From: Martyn White <Martyn.White@arun.gov.uk> **On Behalf Of** Conservation Officer
Sent: 29 July 2022 16:48
To: Planning.Responses <Planning.Responses@arun.gov.uk>
Subject: AW/104/22/PL

AW/104/22/PL

8 Gossamer Lane Aldwick PO21 3AY

1 No bungalow including parking, boundary fence, and alterations to entrance wall and driveway. This application may affect the setting of listed buildings and is in CIL Zone 4 and is CIL Liable as a new dwelling

Drawing
Location, Site, Floor Plans

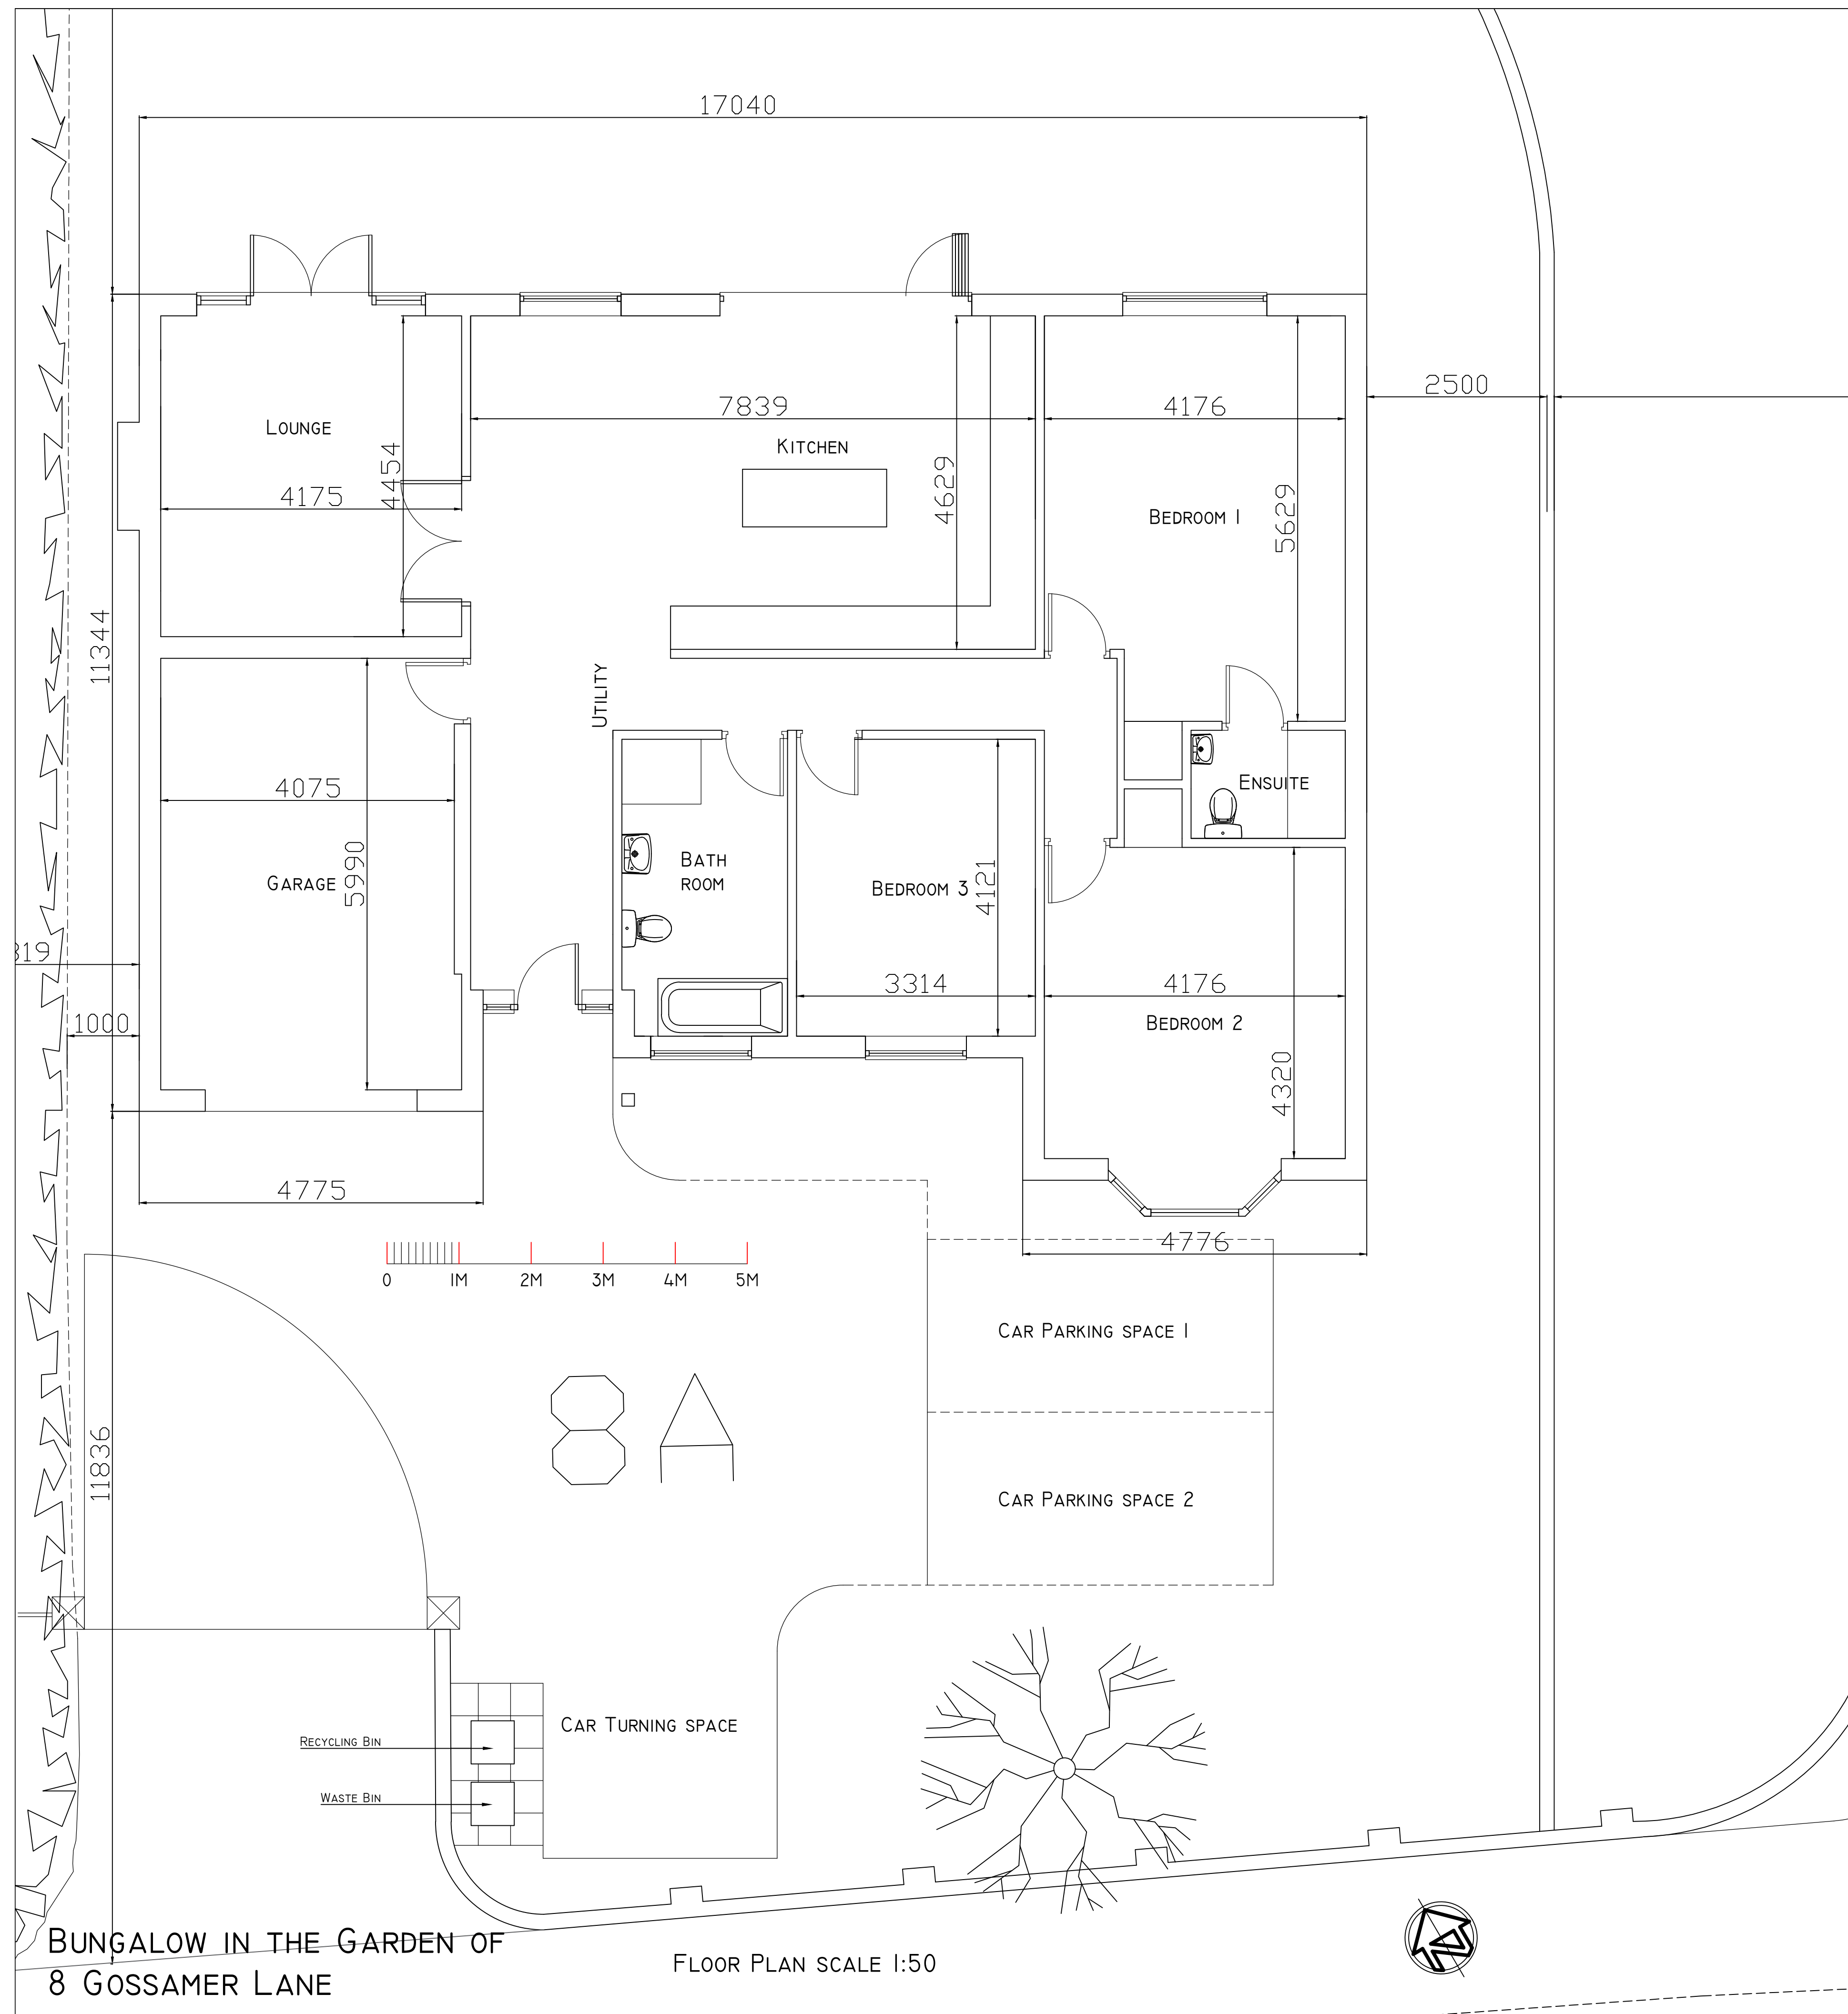
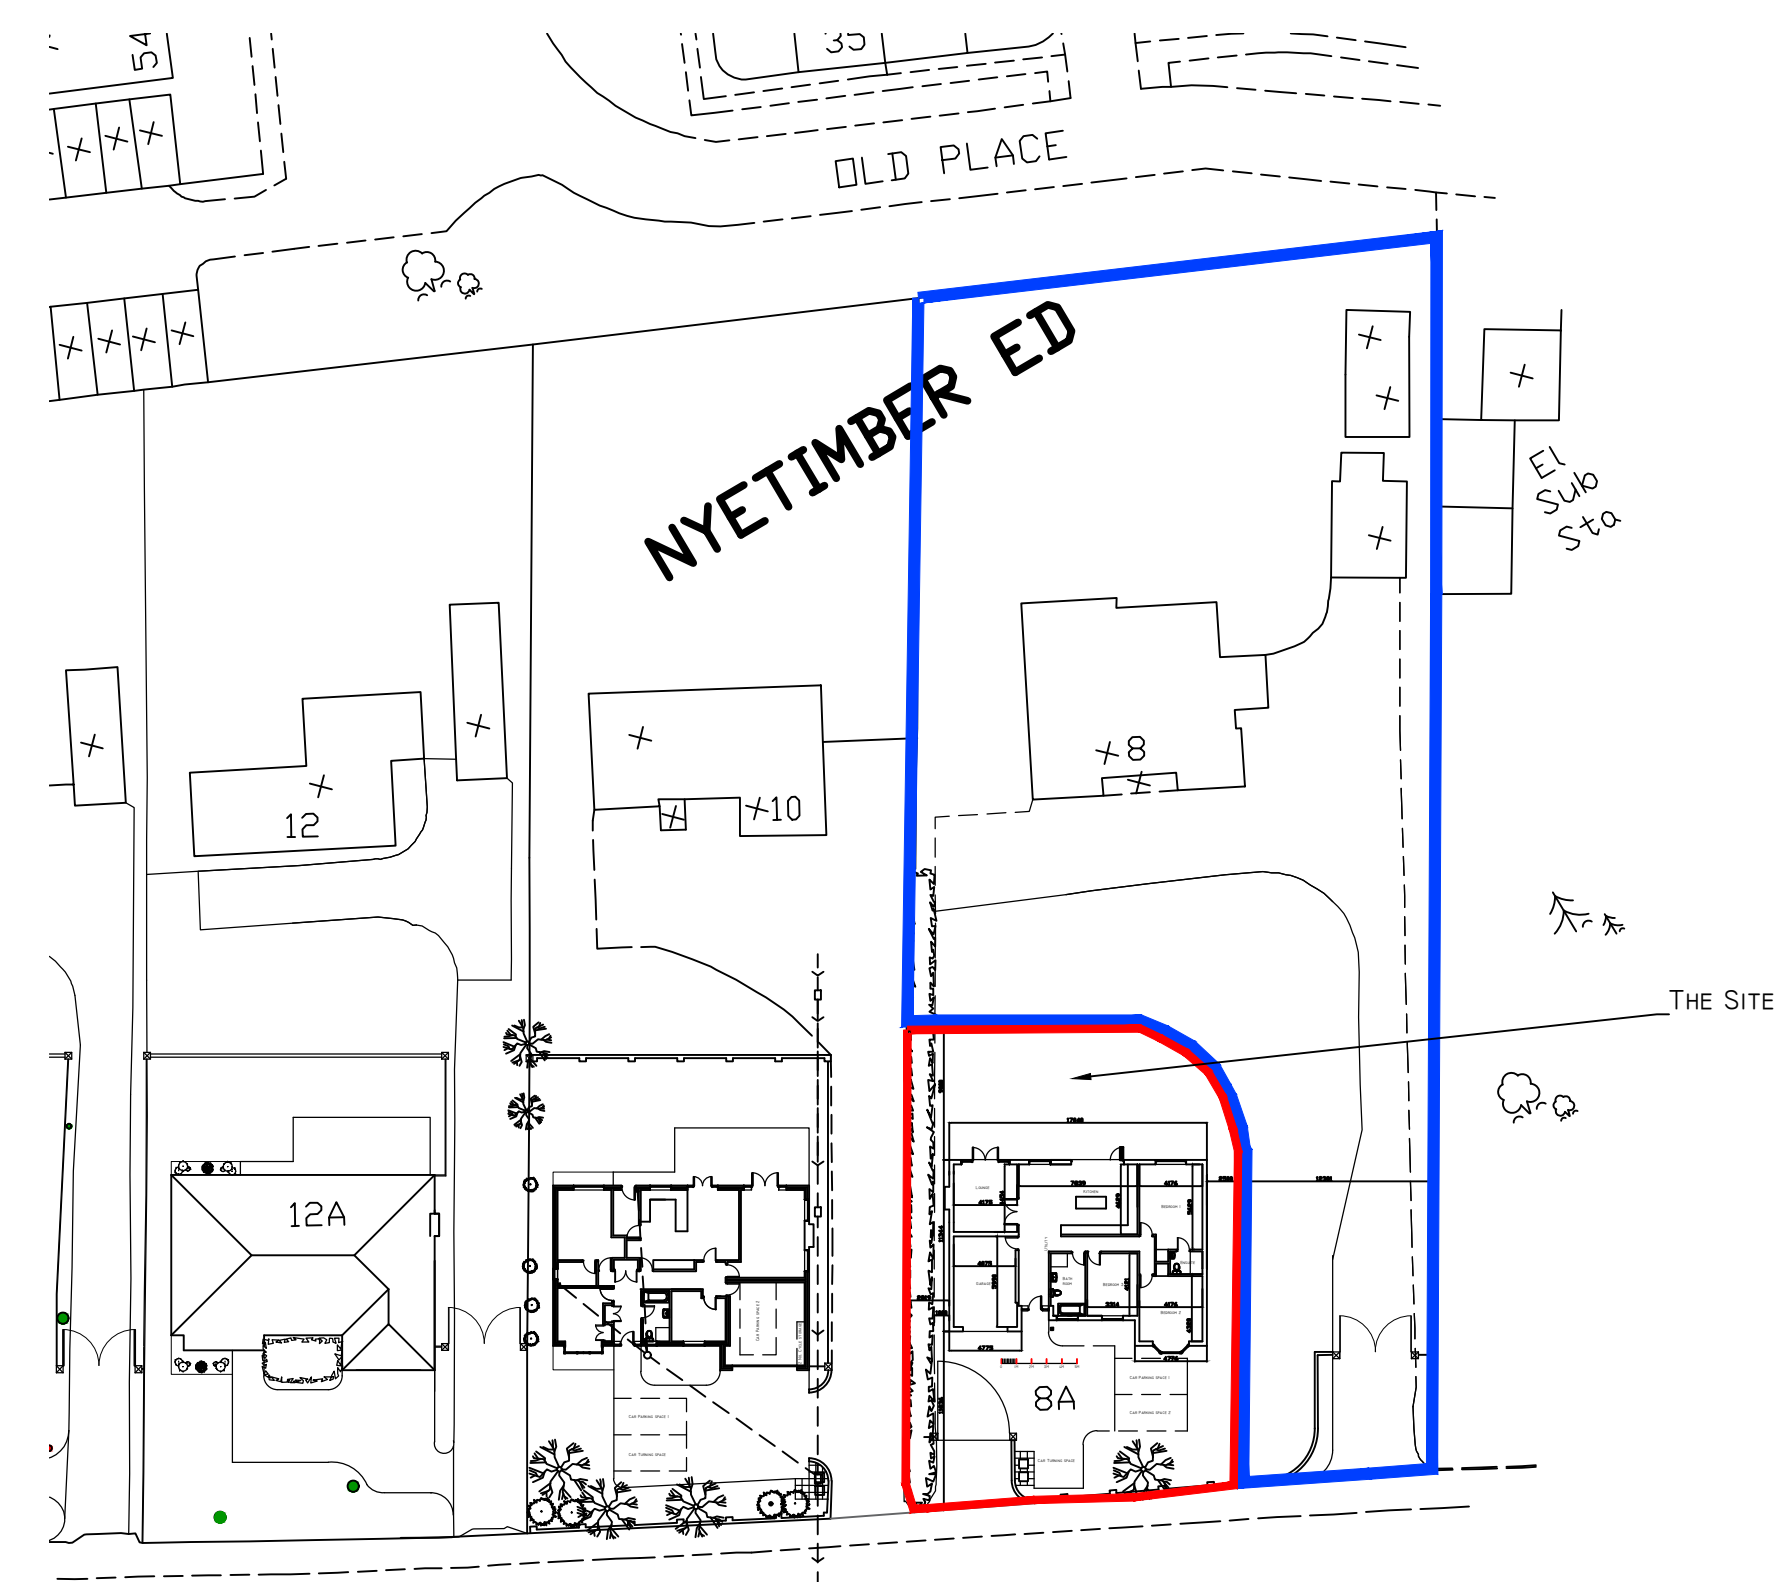
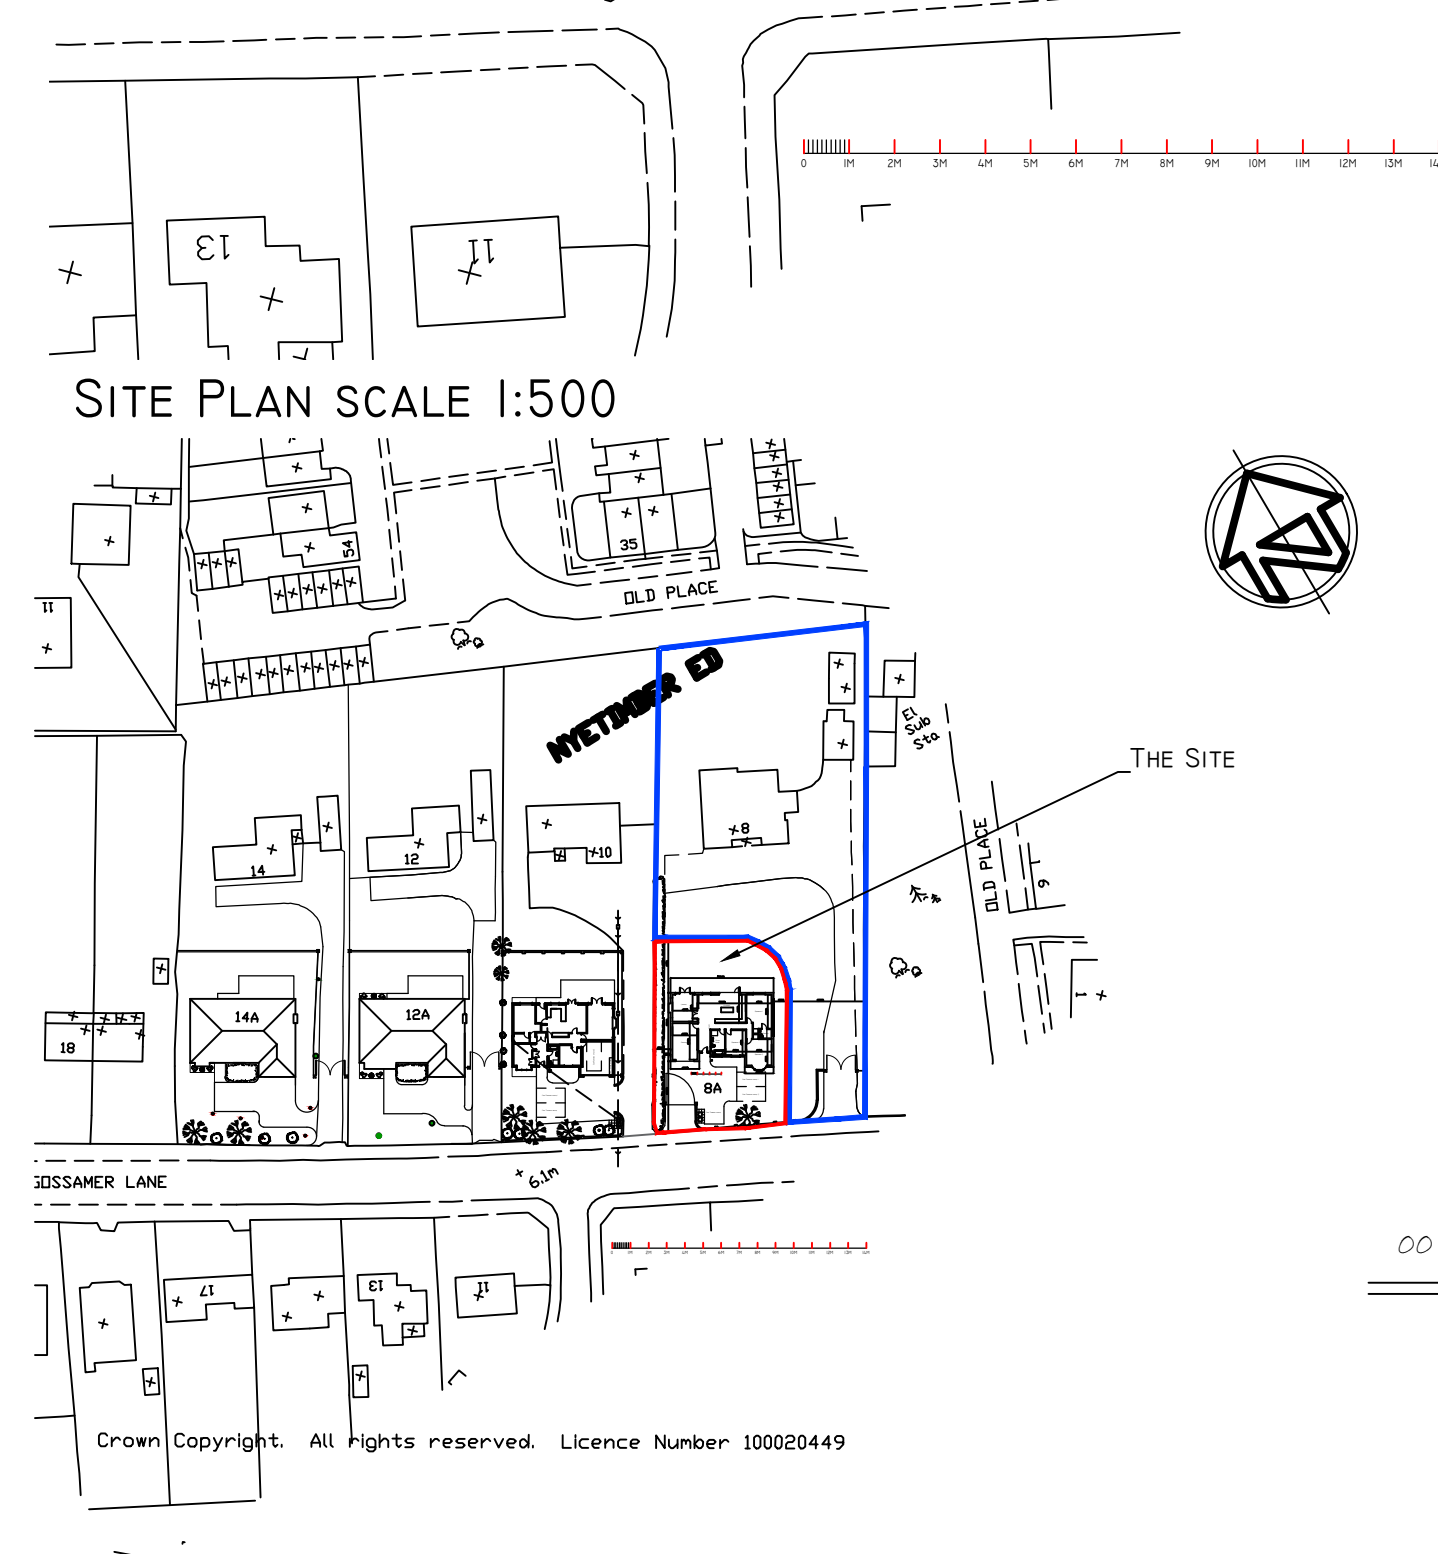
It would appear that the existing (right hand) gate pier to the eastern access point, matches one found within the Old Place development walling. It is recommended that this be retained in position as part of the alterations to the access points. Likewise, the remainder of the existing walling, whilst clearly modern, makes a positive contribution to the street-scene, and every attempt should be made for any alterations and new work to match the existing.
